From: Marge Schmuckal
To: Helen Donaldson
Date: 8/28/2012 4:43 PM
Subject: 433 Fore Street

433 Fore Street - 032-I-040
#2012-558 - B-3 Zone with PAD Overlay (not in Historic District)
8/28/2012

Mark	Date	Description
Project Status		
PLANNING BOARD SUBMISSION		
10/22/12		
Drawing Title		
FLOOR 1 PLAN		
Scale: 1/8" = 1'-0"		
Drawing Number		
A10.1

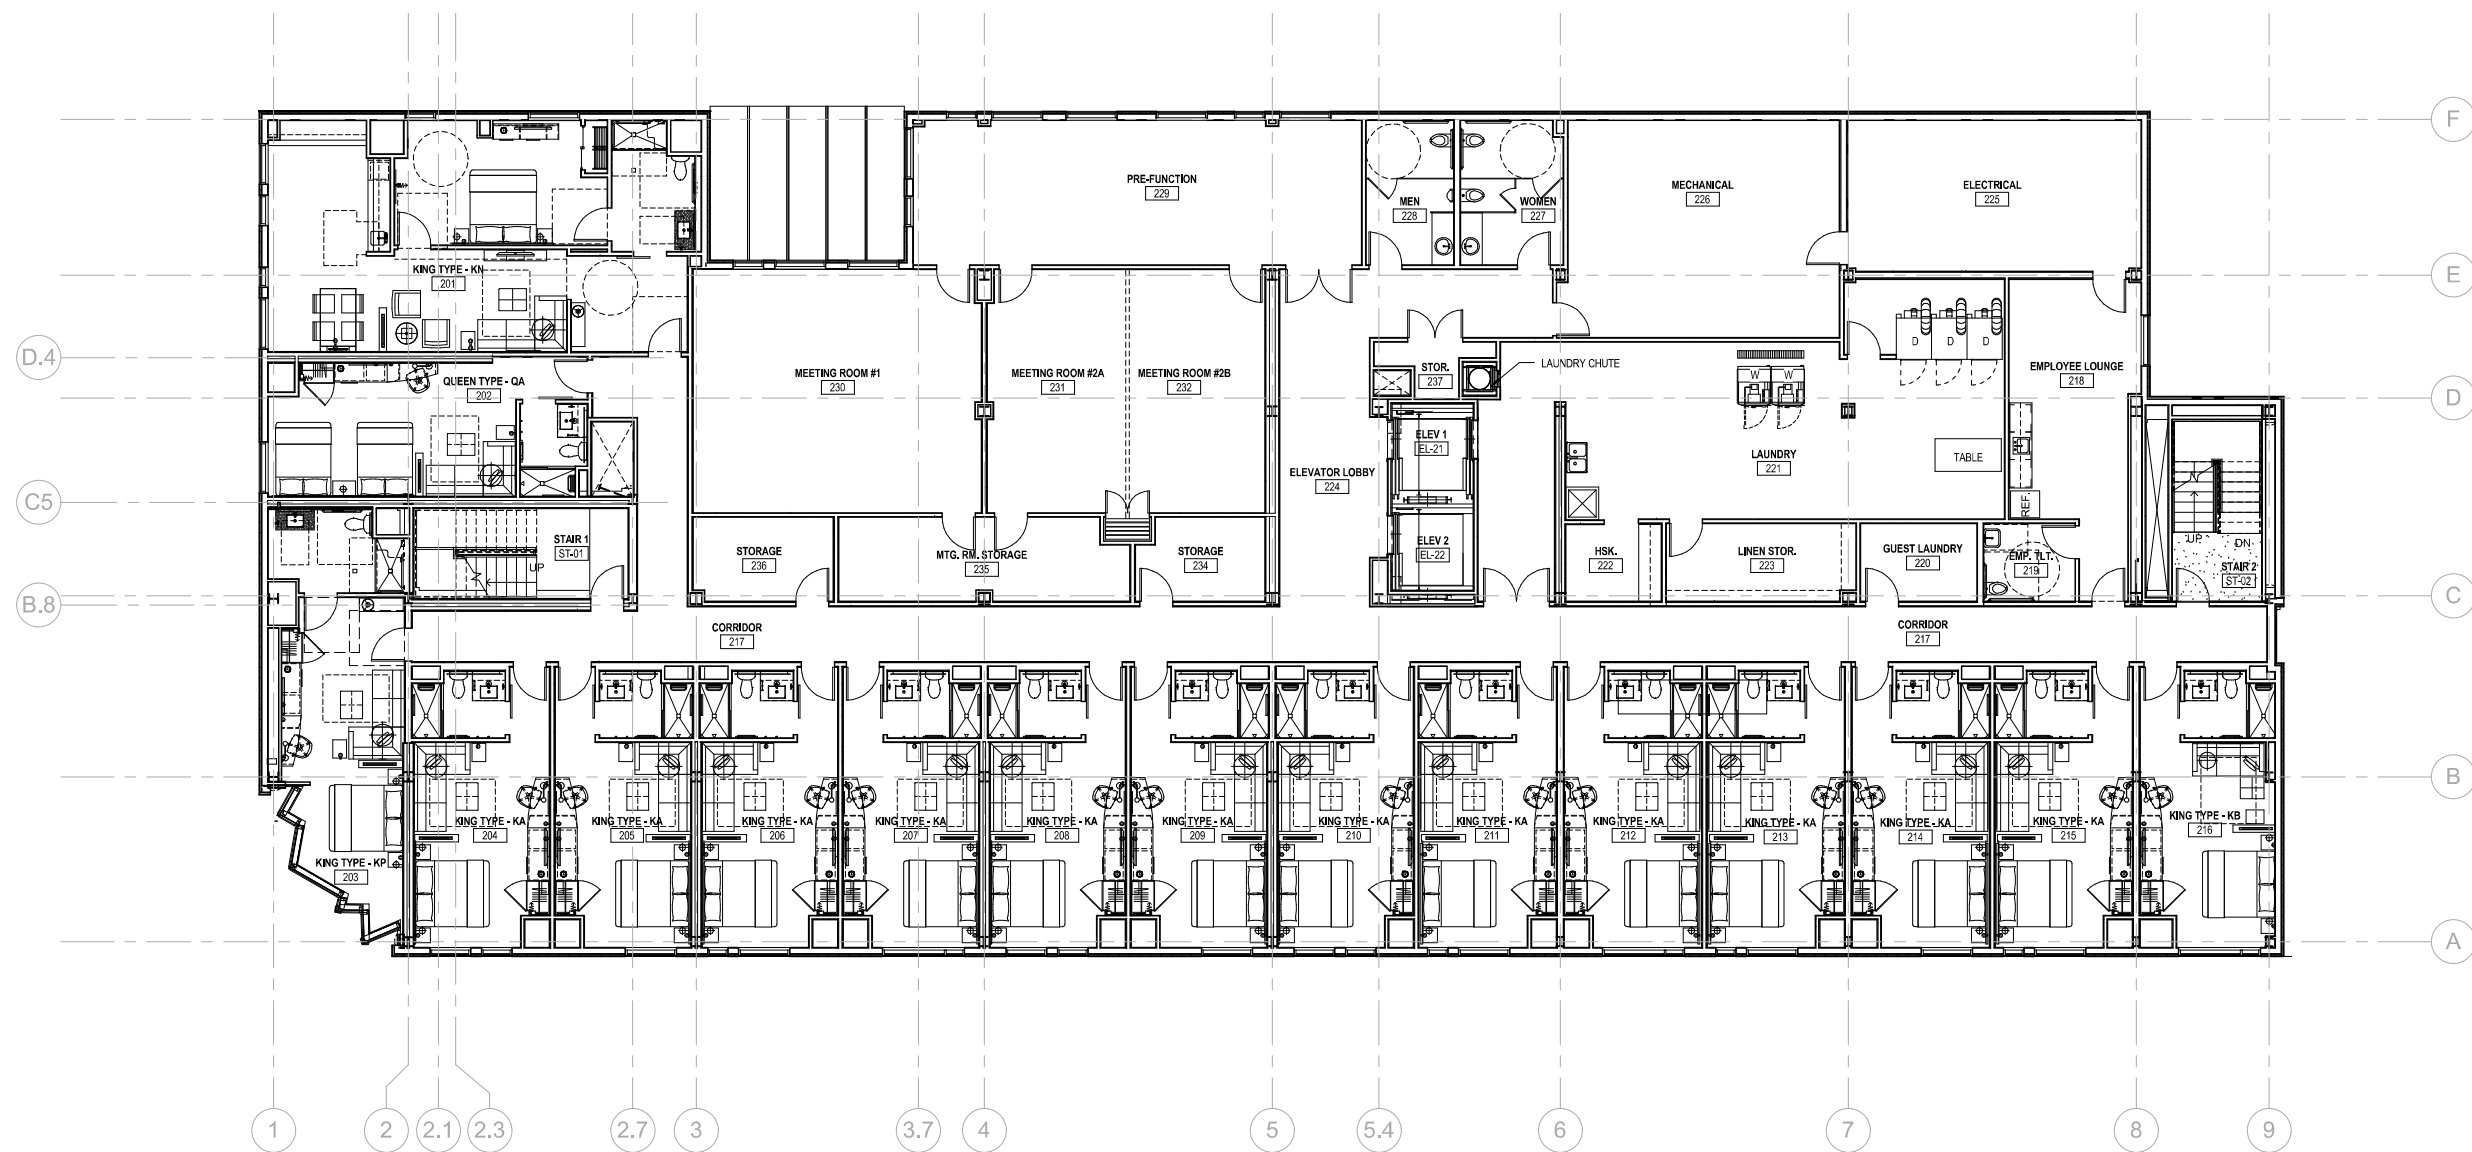
Section 14-220(c) - Street wall build-to requirement is a maximum of 5'. The first floor shows a maximum setback of 16' at the farthest point along Fore Street. There is no definition of the terminology for "street wall build-to line". The rest of the building is overhanging 3.7' from the property line along Fore Street. I determined that the proposed structure is meeting this requirement.
